From: Anita Gardner
Sent: 03 April 2019 14:02
To: Planning.Responses
Subject: FW: LU/3/19/PL

From: Emma Tyler [REDACTED]
Sent: 02 April 2019 13:06
To: Martyn White
Cc: Cllr Geraldine Walker
Subject: LU/3/19/PL

The Conservation Area Advisory Panel would like to submit the following comments regarding the above application as discussed and minuted at their meeting on 1st April 2019.

North Elevation of Building 1

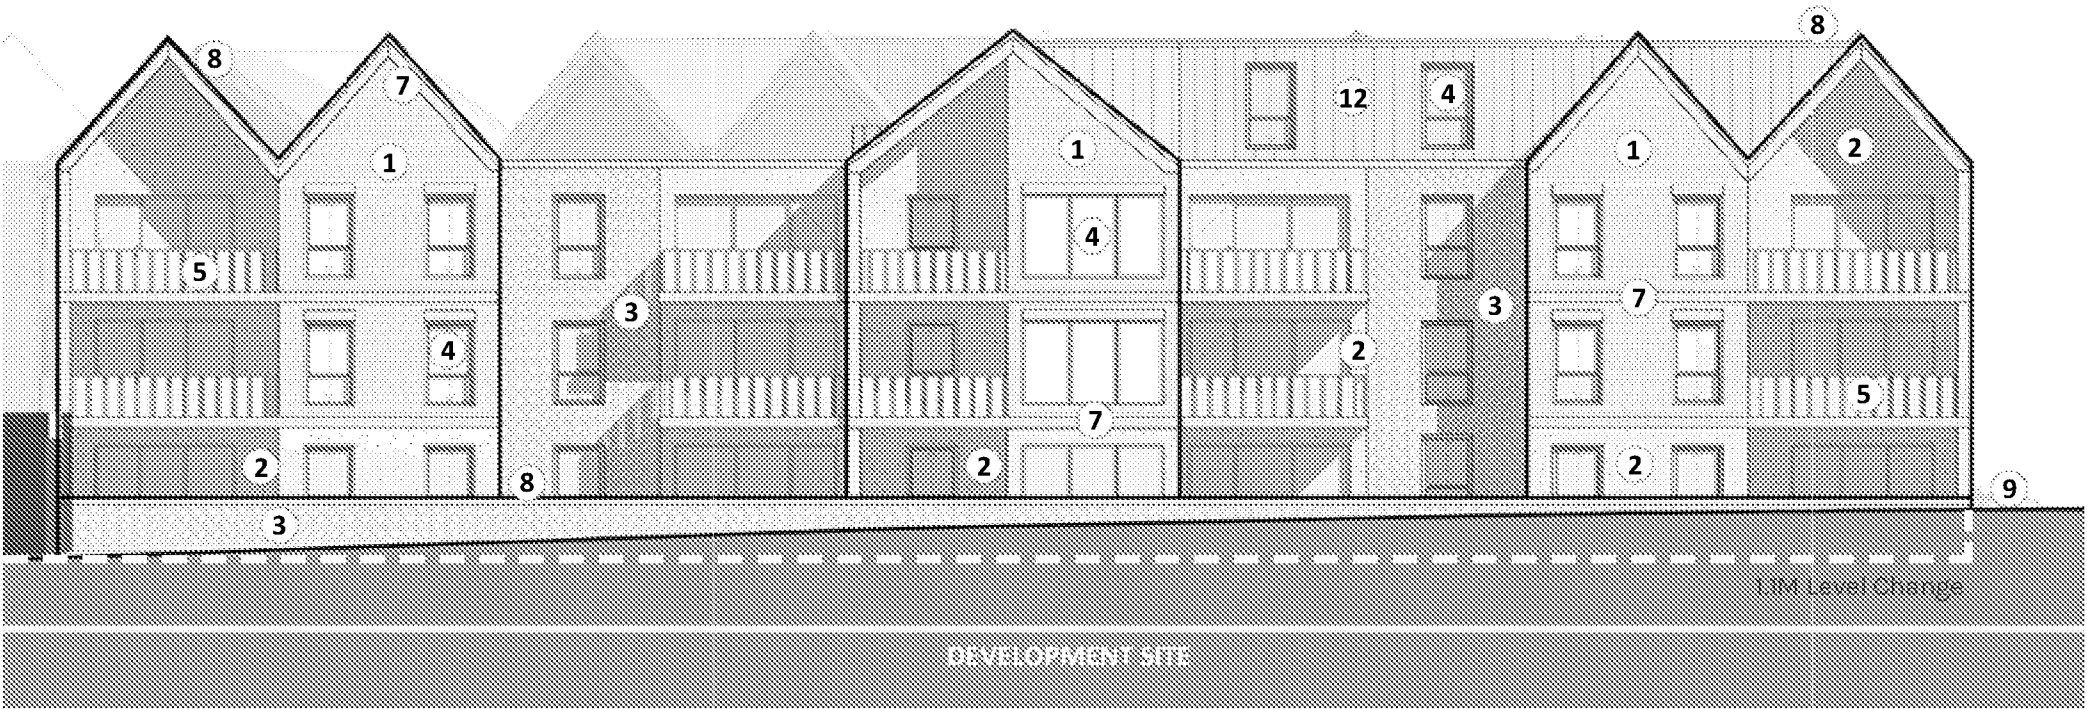
By reason of its scale,height and massing the proposed development will adversely impact on the setting of adjacent and nearby Listed Buildings and also the setting of, and the approaches into, the East Street Conservation Area which forms part of the historic core of Littlehampton.

It is not clear from the plans submitted whether the existing attractive 2 metre high brick and flint highway boundary wall on the Franciscan Way frontage is to be retained or not. The potential loss of this walling would adversely affect the setting of nearby Listed Buildings and also the setting and approach into the conservation area.
